From: Neil Crowther
Sent: 13 November 2014 16:18
To: Planning.Responses
Subject: BE/121/14 DOC
Attachments: 5626AFD1-E08A-4E34-B218D75FAF16E35D.PDF; Scan - 06-08-2014.pdf; 140134-ED-05a Oldlands Farm Water Vole Report.pdf.pdf; C14443-400 - T2 Attenuation pond - Levels.pdf; C14443-220 T1 Outfall details.pdf

Sent: 12 November 2014 11:40
To: Neil Crowther
Subject: C14443 RE: Oldlands Farm - Surface Water Drainage Conditions BE/121/14 DOC

Subject: C14443 RE: Oldlands Farm - Surface Water Drainage Conditions BE/121/14 DOC

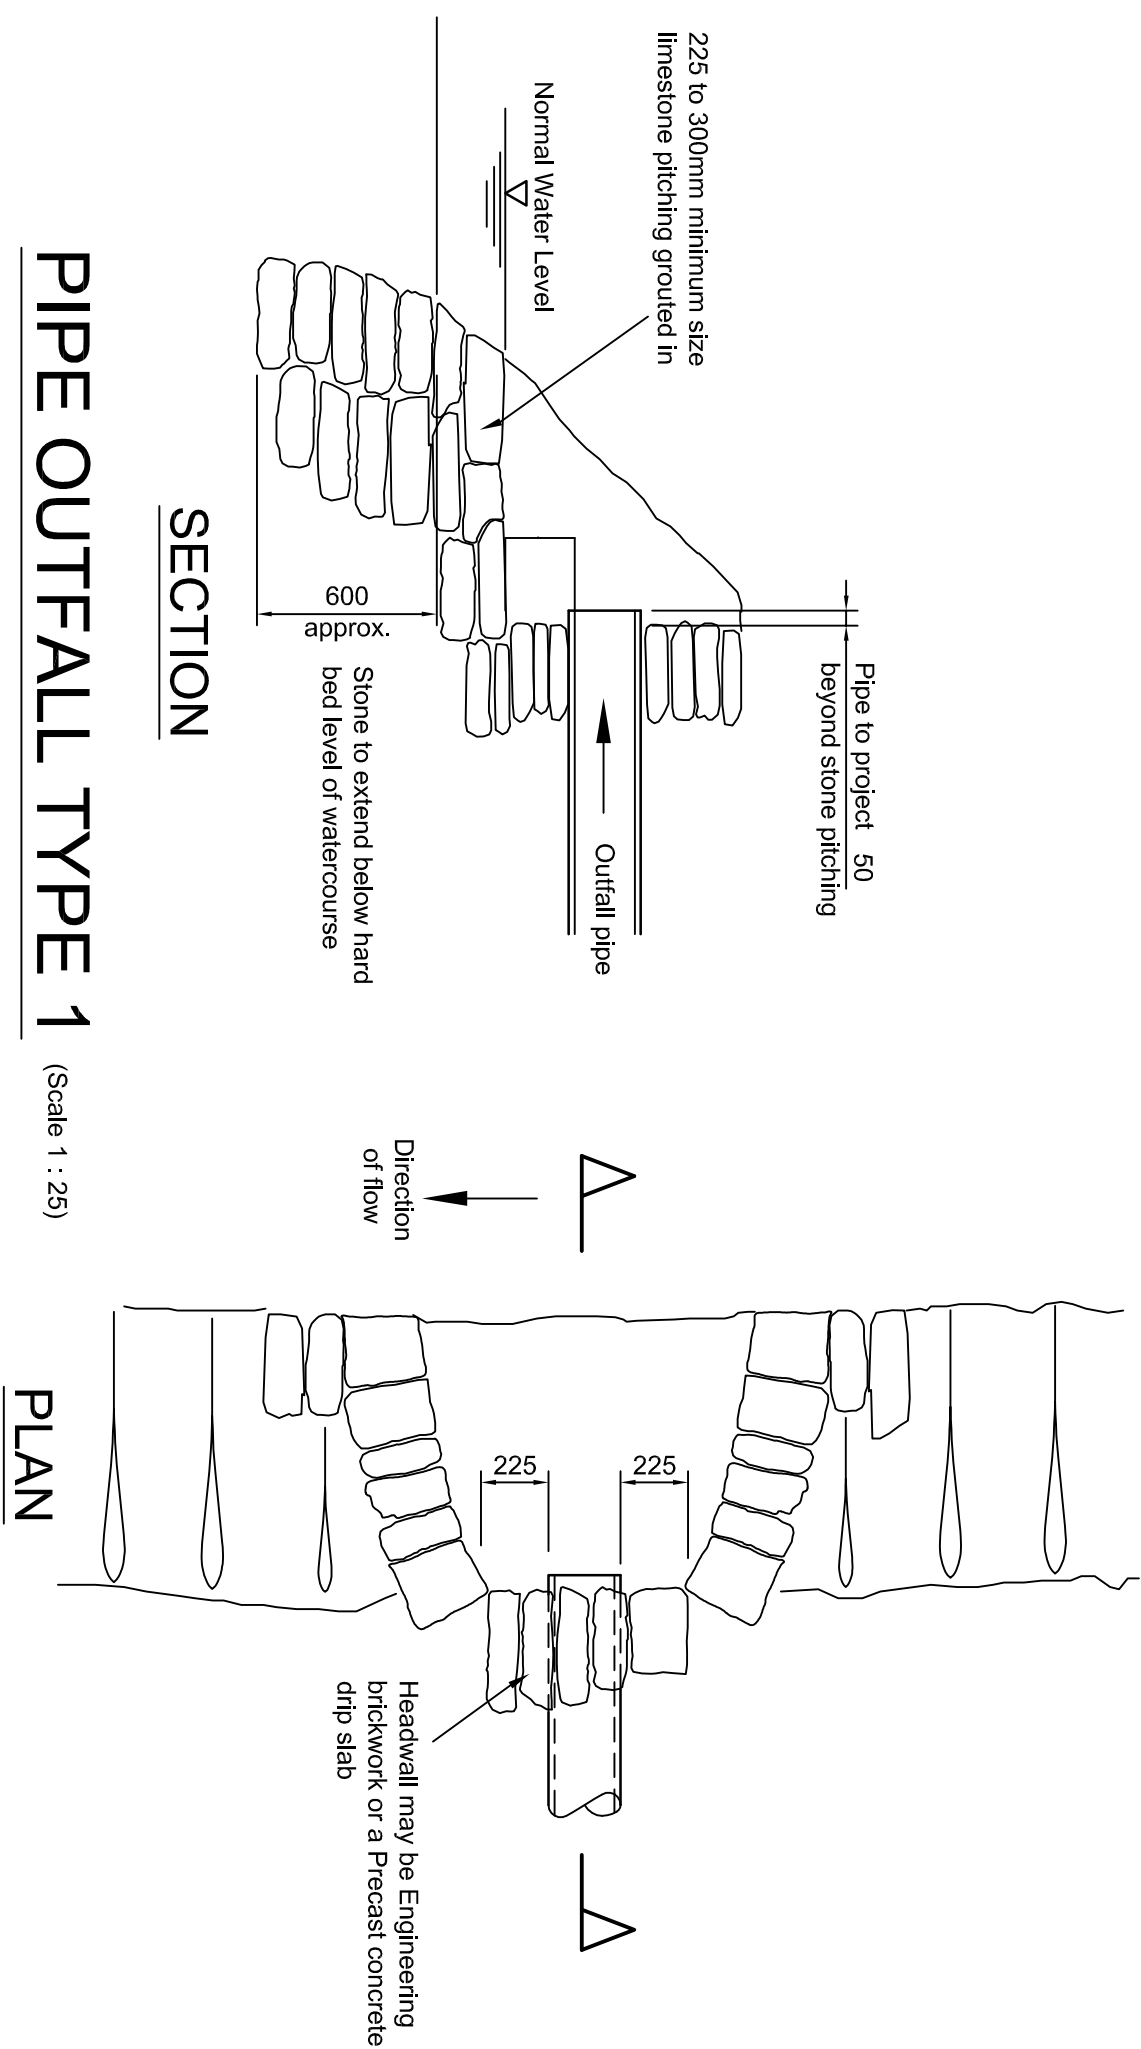
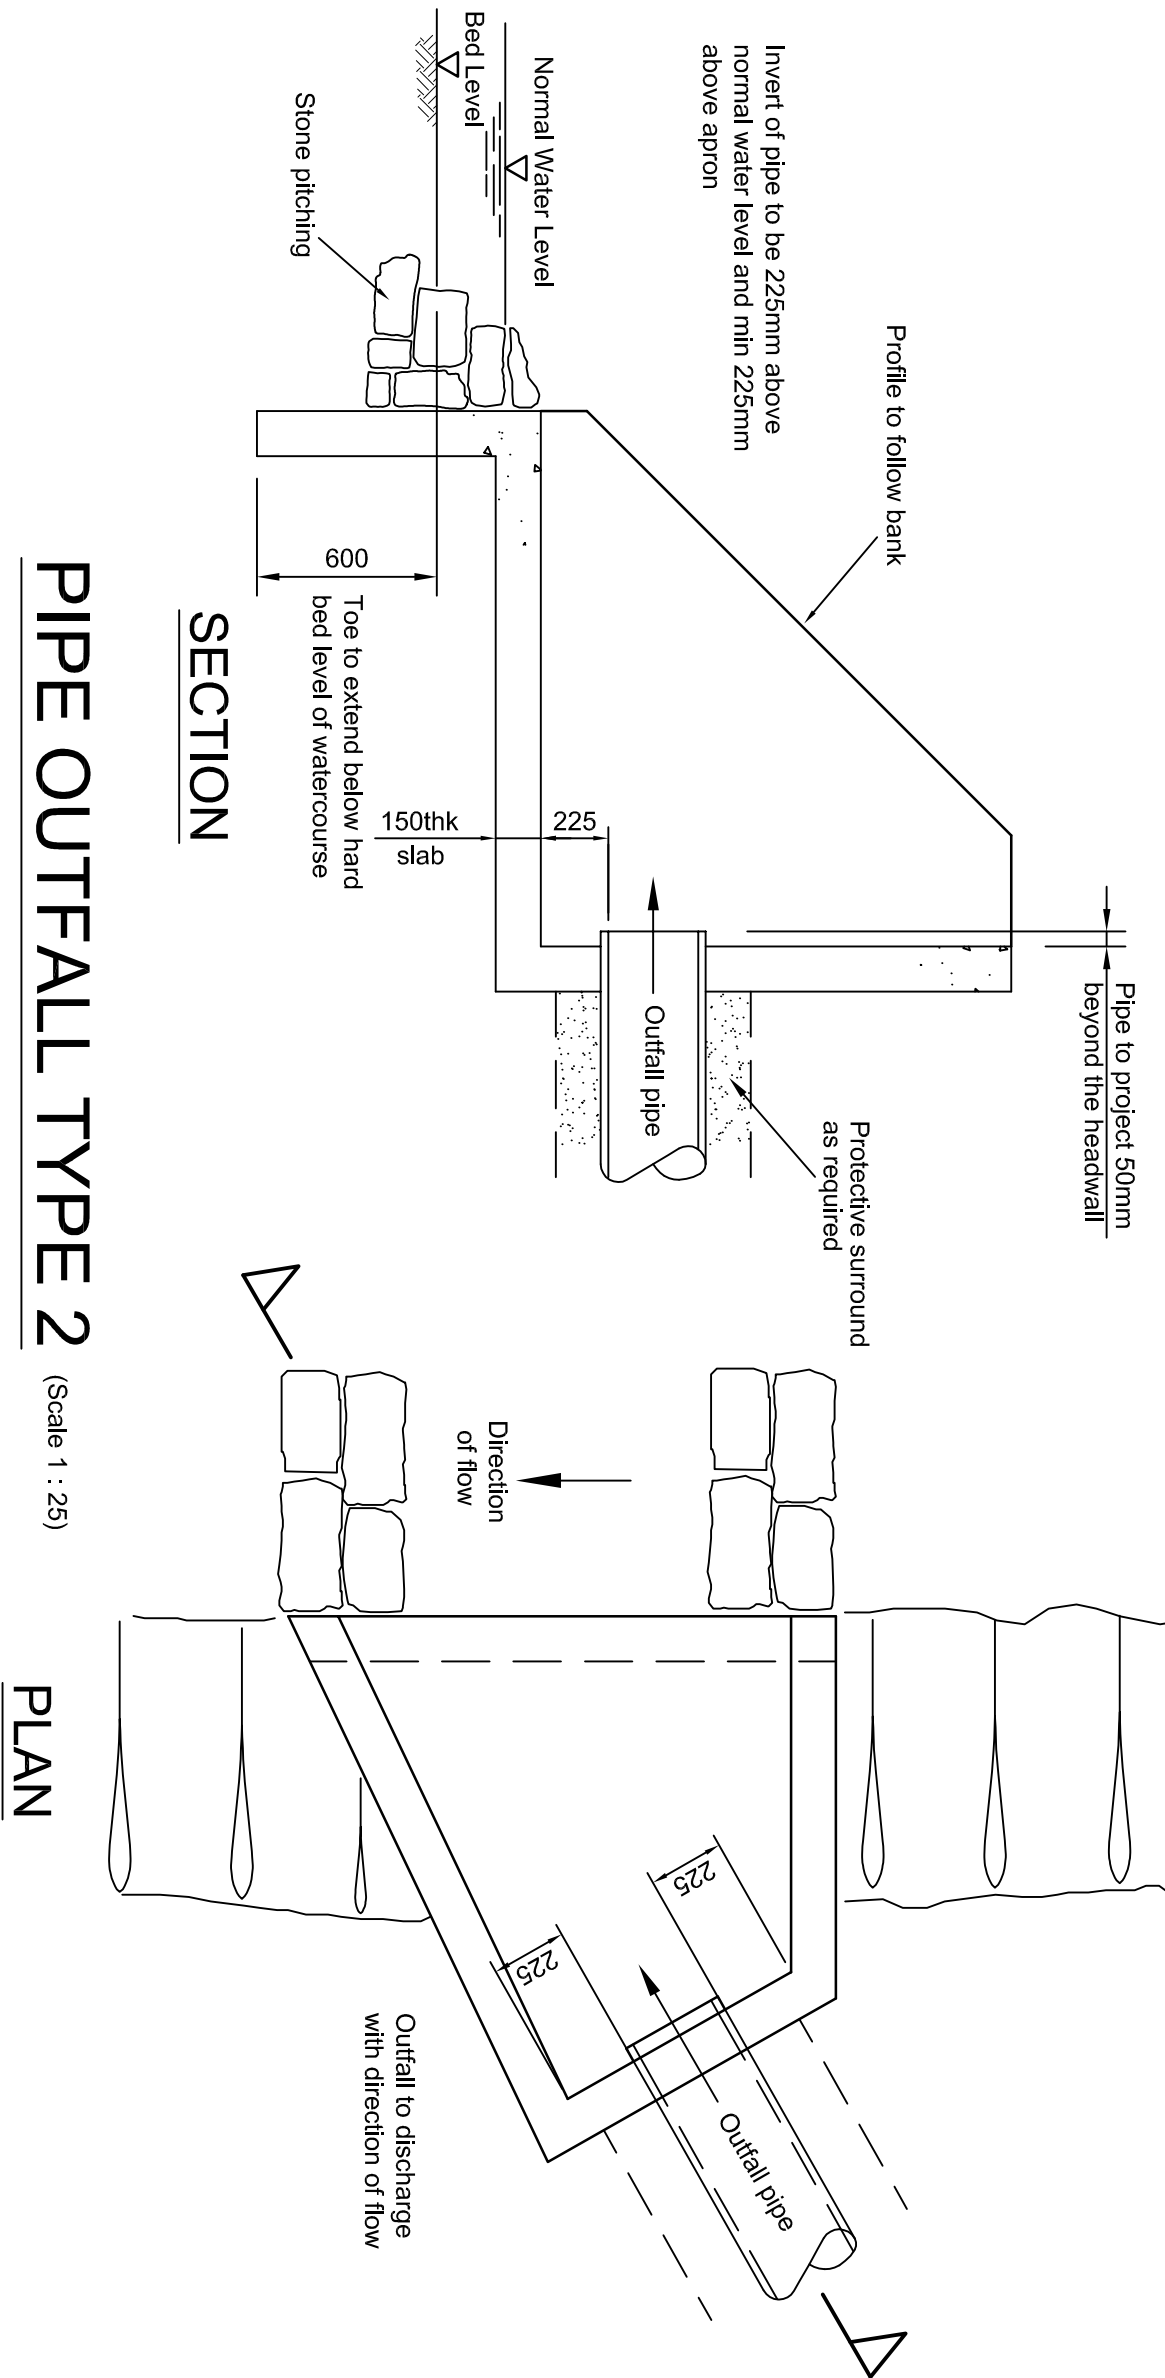
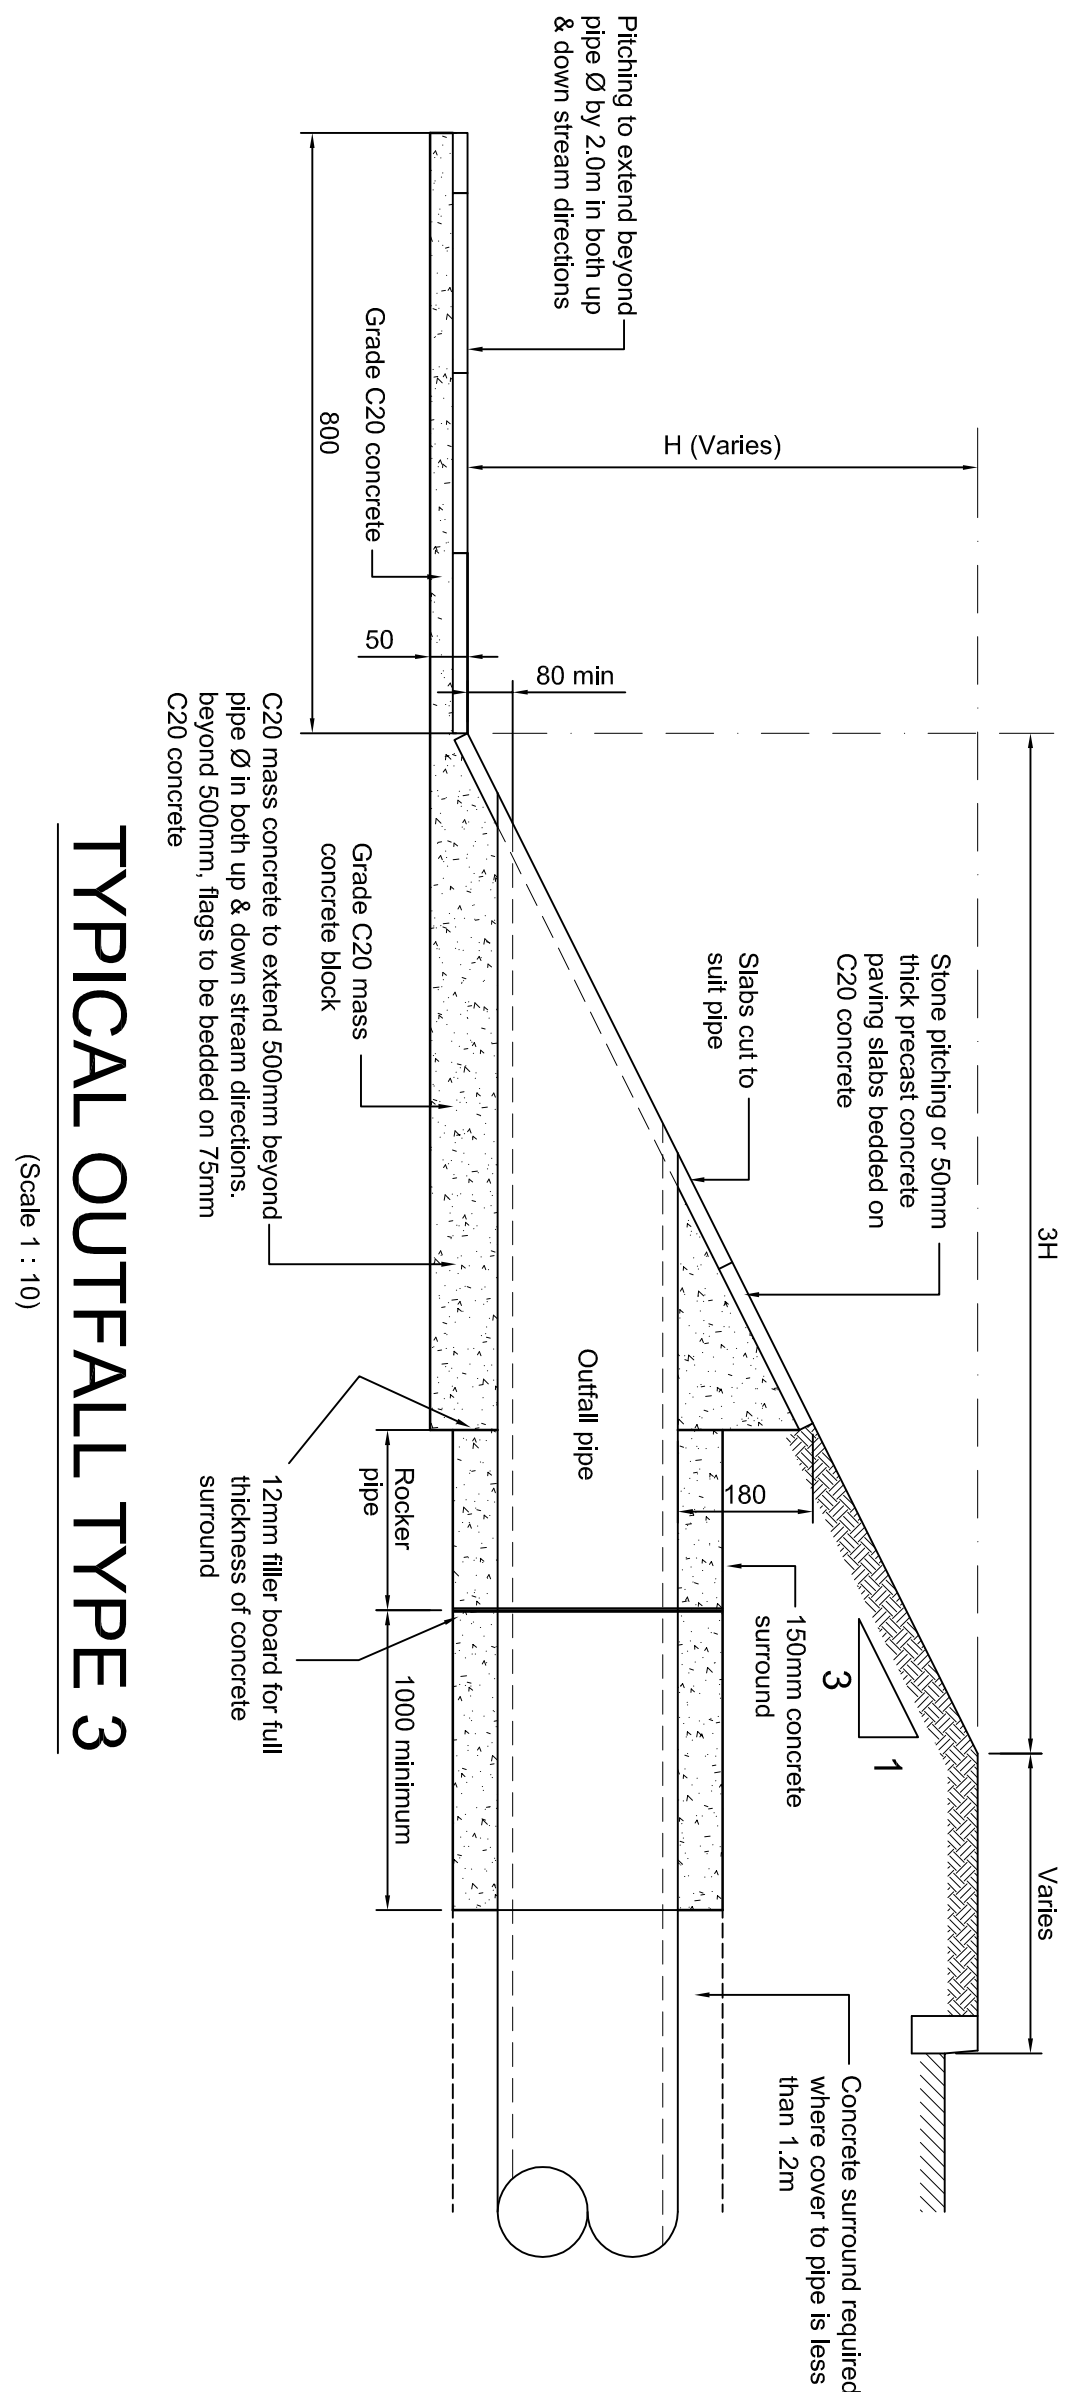
5. Outflow from pond to dry ditch has been angled further to direct flows into the channel.
6. The planning condition does not ask for construction drawings of the details you mention which will be submitted as part of the building control approval process. Drawing 220 attached gives outfall options for the contractor to price, it is likely that a precast outfall will be used. Given the nature of the ground, there will be no liner to the pond.

PLAN ON ATTENUATION POND  
Scale 1: 500

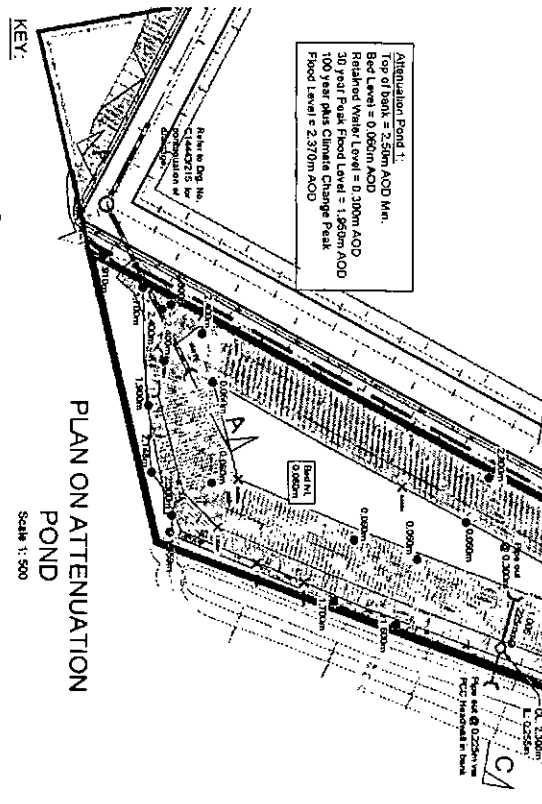
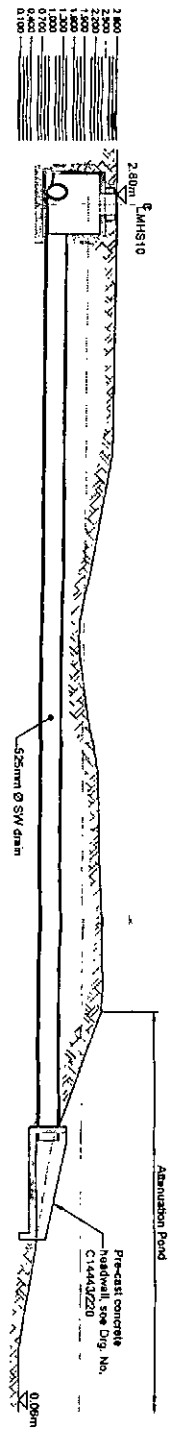
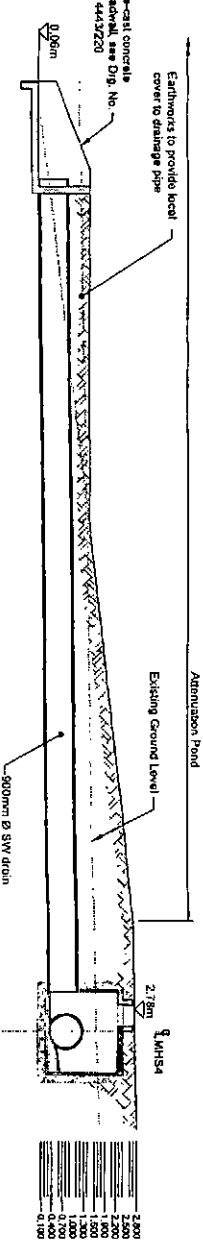
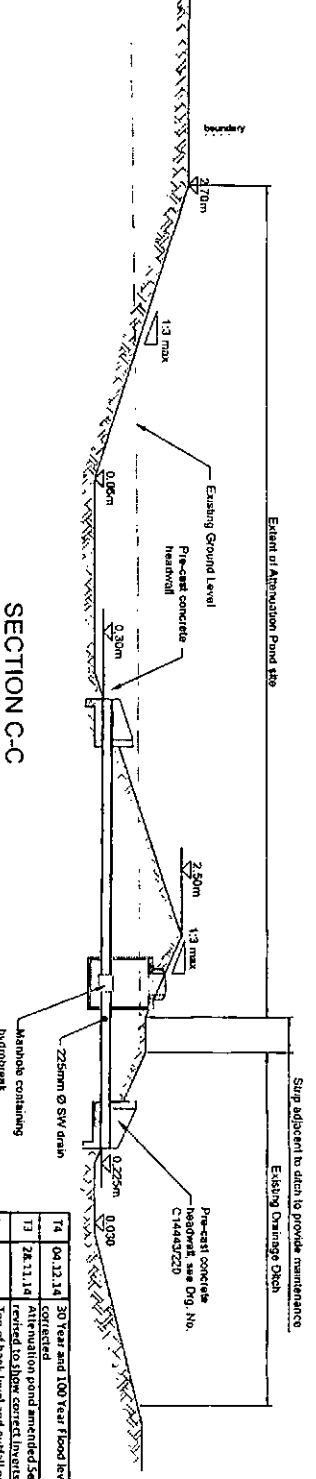
2. While we don't believe there is any guidance to support the case for 300mm freeboard. Recent re-modelling of the pond is providing the level of freeboard you would like to see. I attach the latest pond layout for reference.
